LIME DOWN SOLAR PROJECT

DEADLINE 5 SUBMISSIONS STOP LIME DOWN

August 2026

Fig 1: Area D in relation to EA flood zones. Pinkish areas in numbered fields are solar panels. Green areas are substations, orange, the BESS. EA Flood Zone 3 (>1% AEP) is shown in dark blue; Flood Zone 2 (0.1 to 1% AEP) in light blue; remaining areas are Flood Zone 1 (<0.1% AEP)

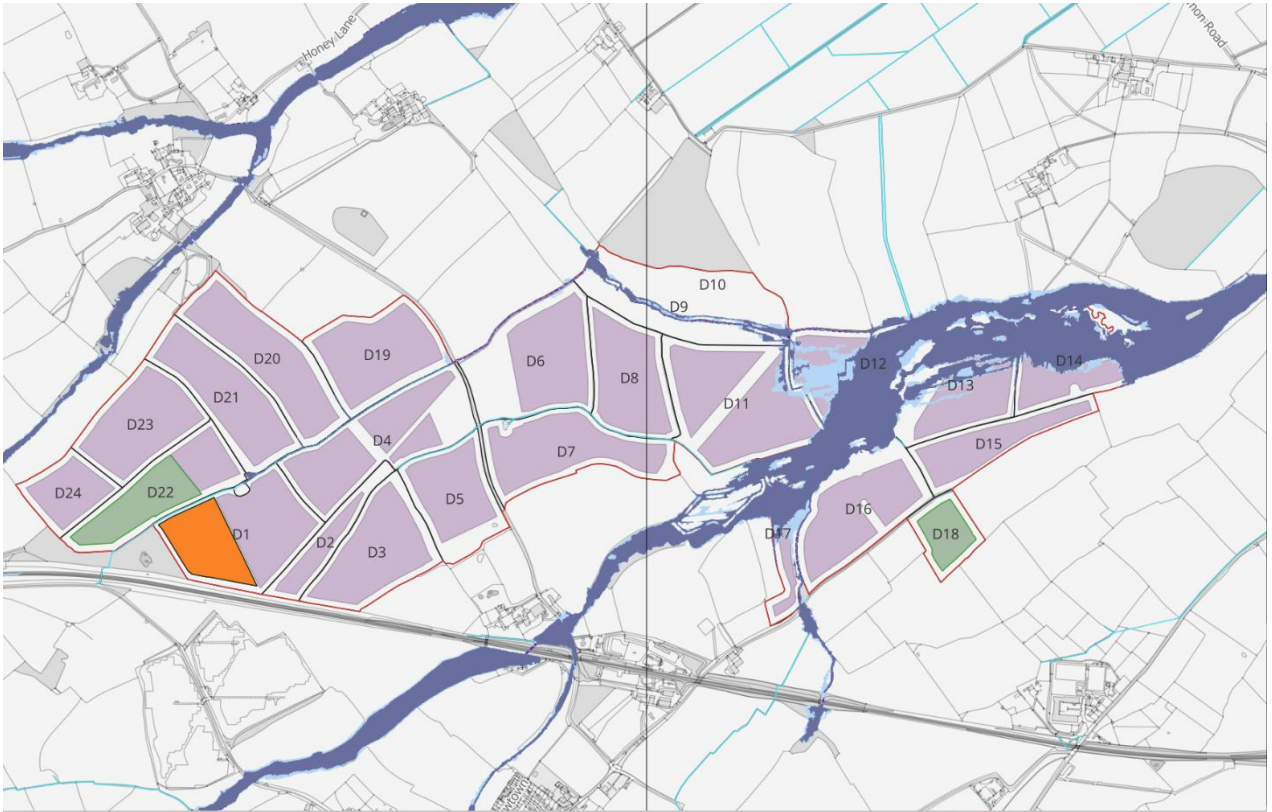
2.6.21. SLD-027 and SLD-028: These points concern the photograph of extensive flooding in Area D due to Storm Bert, and the implications for the Applicant's flood modelling. On both these points, the Applicant provides lists of information which could never be determined from an image, and have never been claimed to do so by Stop Lime Down, such as rainfall return periods, antecedent conditions, blockage conditions.

2.6.22. The Applicant also states, at both SLD-027 and SLD-028, that "*The photographs are oblique views taken during a storm event. They cannot be accurately or definitively located, time checked, or used to identify the flood extent.*" This is incorrect. All image files have embedded a hidden file of metadata called an EXIF file, which records information about the image depending on the technology used to take it. It can be accessed using a suitable program. The EXIF file for the original video used to produce the images in SLD's Written Representation, Appendix F1 **[REP1-174]**, states that it was taken on 24.11.2024 at 15:26:11, more than 3 hours before the flood peak as stated in **[REP1-174]**. As the phone camera included a GPS, the location was recorded as 51° 33' 9.00" N; 2° 7' 19.92" W; 73.401 m ASL. This is the location shown on Figs 3 and 4 in **[REP-174]**. The angles of view in the figures were determined from landmarks in the photographs: the fence line, West Park Wood and Bradfield Wood. The position of the photograph is thus known to the nearest metre, the time to the nearest second, and the only limitation on assessment of the flood extent is that it clearly extends outside the picture boundary. SLD would be happy to supply the video file to the ExA and the Applicant on request to verify the EXIF data. We recommend metadata2go as the access program.

2.6.23. The relevant point made by the Applicant is that *"The Applicant does not agree that the photographs demonstrate that flood extents were greater than predicted by the Applicant's assessment"*. SLD continues to maintain that the photographs show exactly that. As described in SLD's Written Representation, Appendix F1 [REP1-174], Storm Bert was approximately a 1% AEP event which should correspond to Flood Zone 3. The photographs clearly show that the flood extent was greater than that predicted by the Applicant's modelling of this event as shown in ES Appendix 11-6: Flood Risk Assessment and Outline Drainage Strategy – Lime Down D Rev 4 [REP4-032]. Coupled with other evidence of underestimation (see Appendix D) it calls into question the Applicant's conclusions from its FRAs, particularly concerning off-site flooding.

Title:
Figure 13-5: Abnormal Load Routes: Solar PV Sites

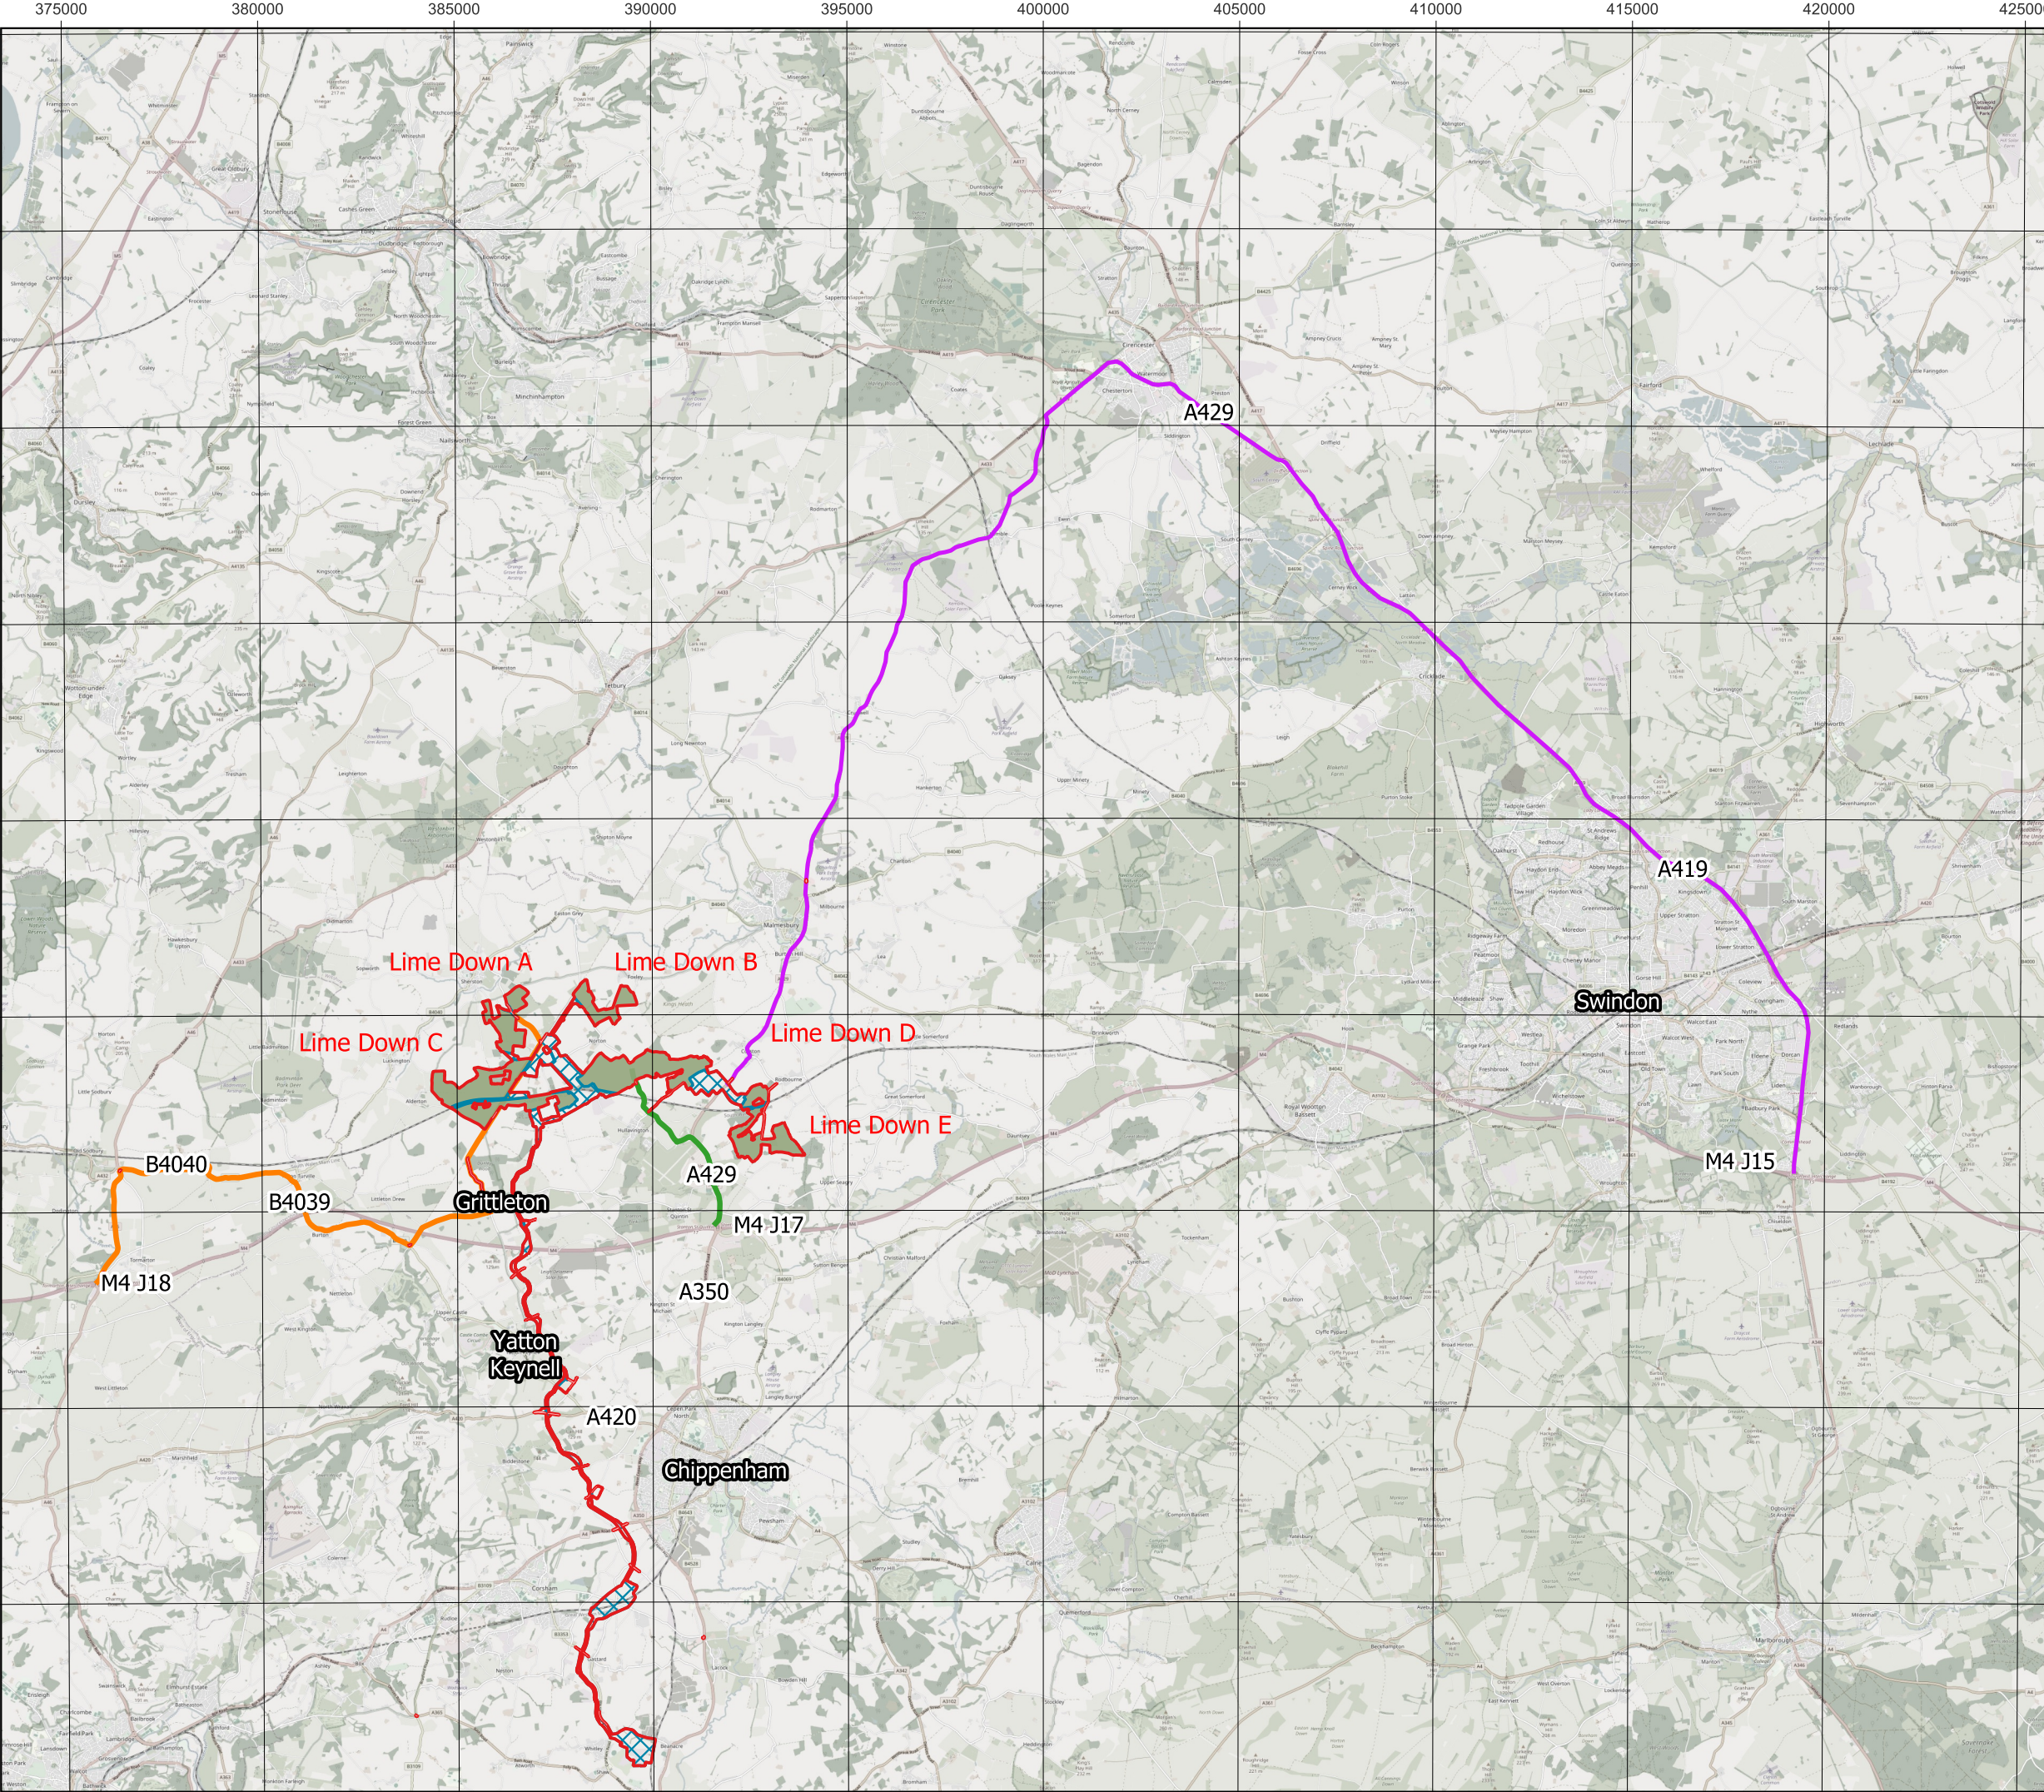
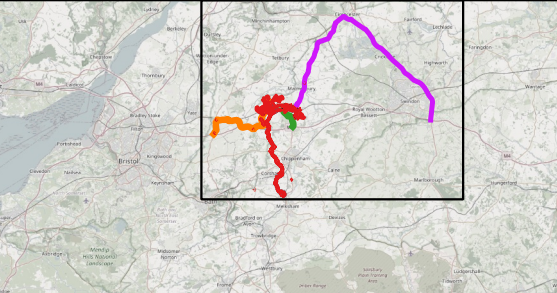
REP4-017 – ES Vol 2, Figure 13-5 Abnormal Load Routes – Solar PV Sites

2.2.1. Mr. Bamber notes that the alternative AIL route to Areas A and C that approaches from the south at Grittleton crossroads has been removed. All AIL vehicles would therefore need to make the left turn at Grittleton crossroads to enter Alderton Road. Mr. Bamber notes that this issue has been picked up at the ExA's Second Written Questions TT2.8 and will review the Applicant's response and respond when able. The point is made by the ExA that there is no swept path analysis showing how the AIL vehicle could make the left turn into Alderton Road and details are requested of a possible manoeuvre whereby the AIL vehicle turns right towards Yatton Keynell, the tractor unit unhitches, re-hitches to the rear of the trailer unit and continues north along Alderton Road.
